Our ref: OUT22/19800

Subject: **Yiribana Logistics Estate (SSD10272349) - Response to Submissions (RtS)**

Detailed advice to DPE Planning & Assessment regarding the Yiribana Logistics Estate (SSD10272349) - Response to Submissions (RtS)

E2 CORRIDOR ALIGNMENT PLAN
SCALE 1:500

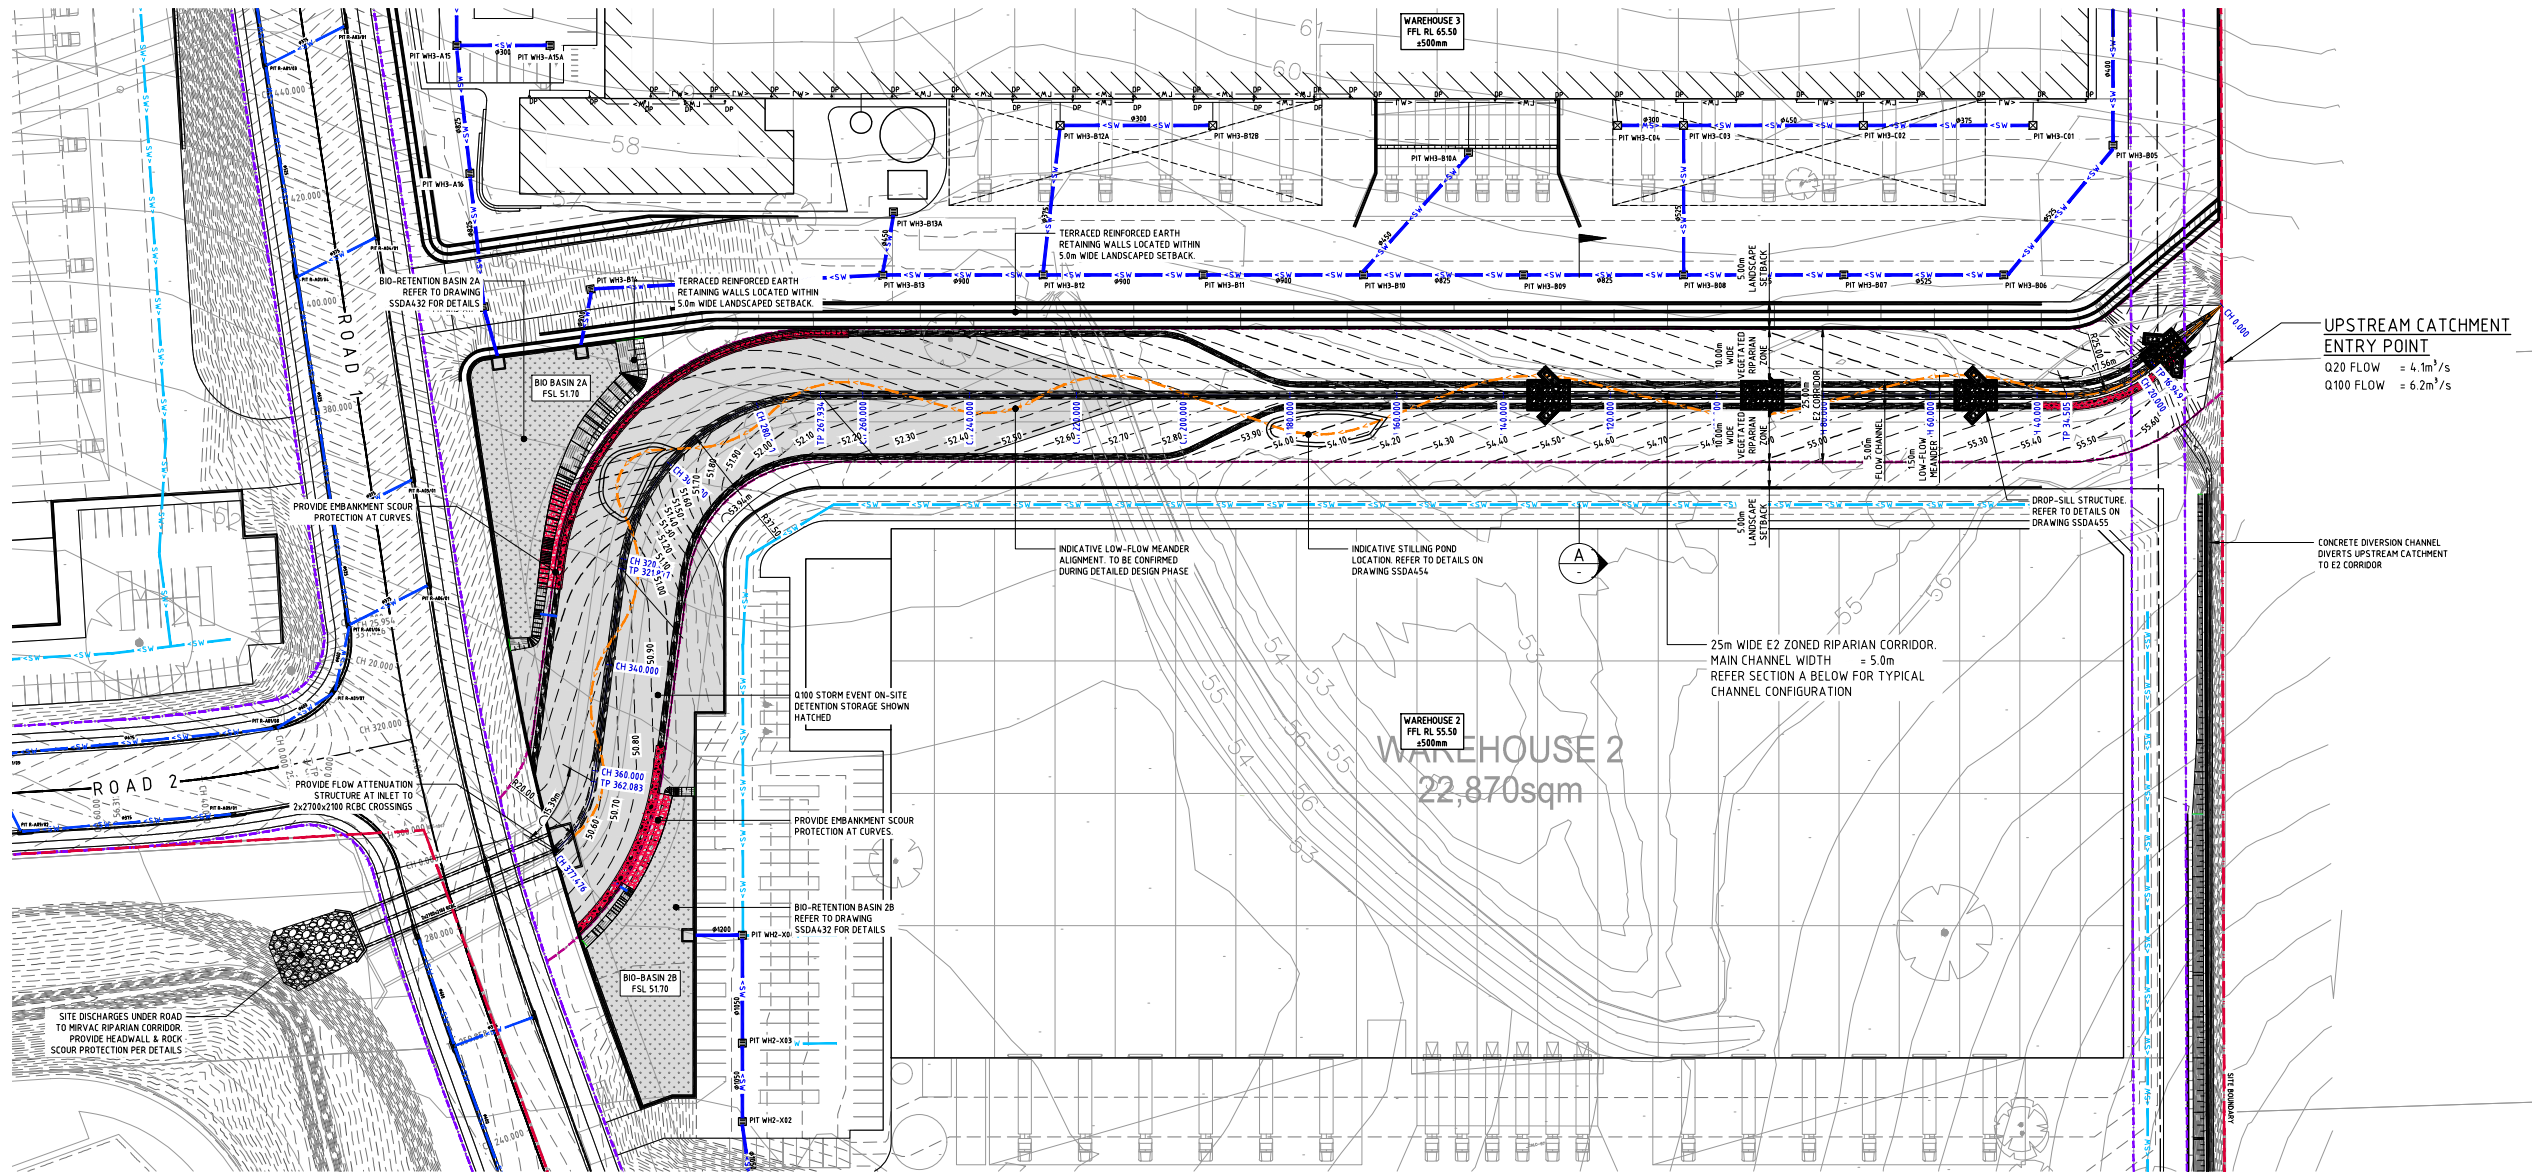
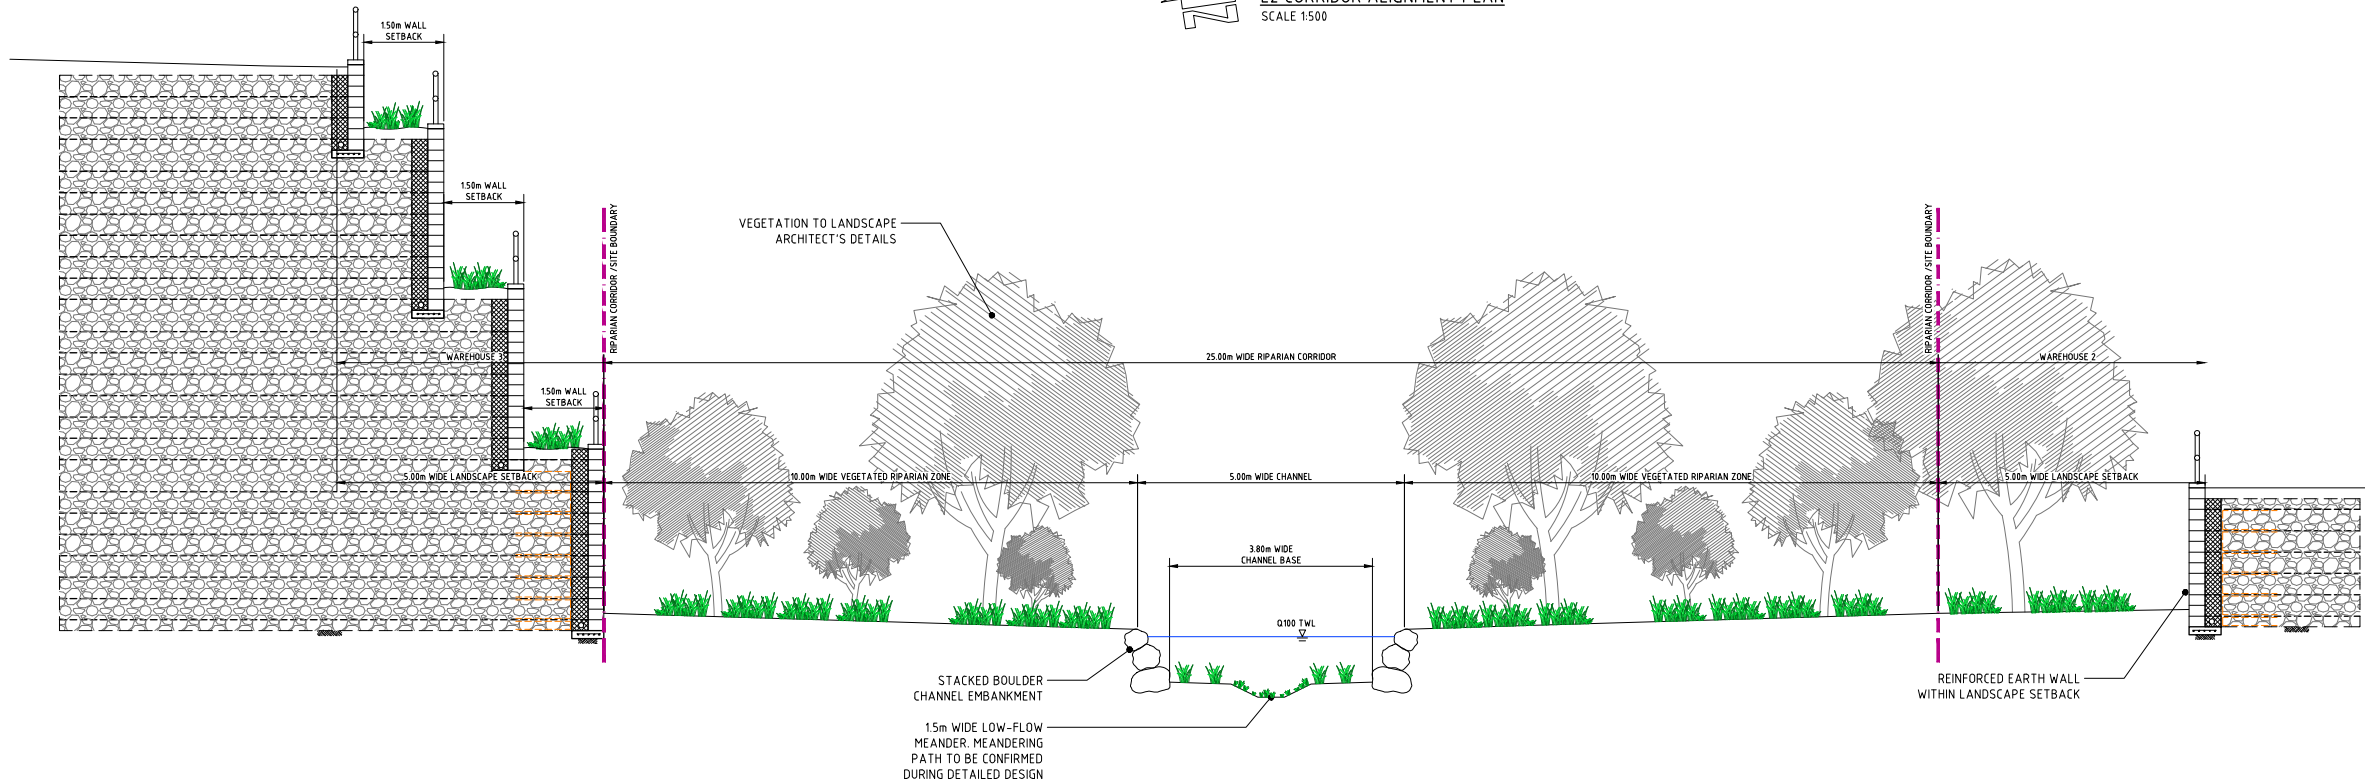
The proponent has committed to a 40m riparian zone, demonstrated in the provided Civil Plans. This is supported and it is recommended that this be planted in accordance with the Guidelines for Controlled Activities on Waterfront Land – Vegetation Management Plans.

The proponent should ensure that the riparian zone vegetation be planted in accordance with the NSW Guidelines for Controlled Activities on Waterfront Land.
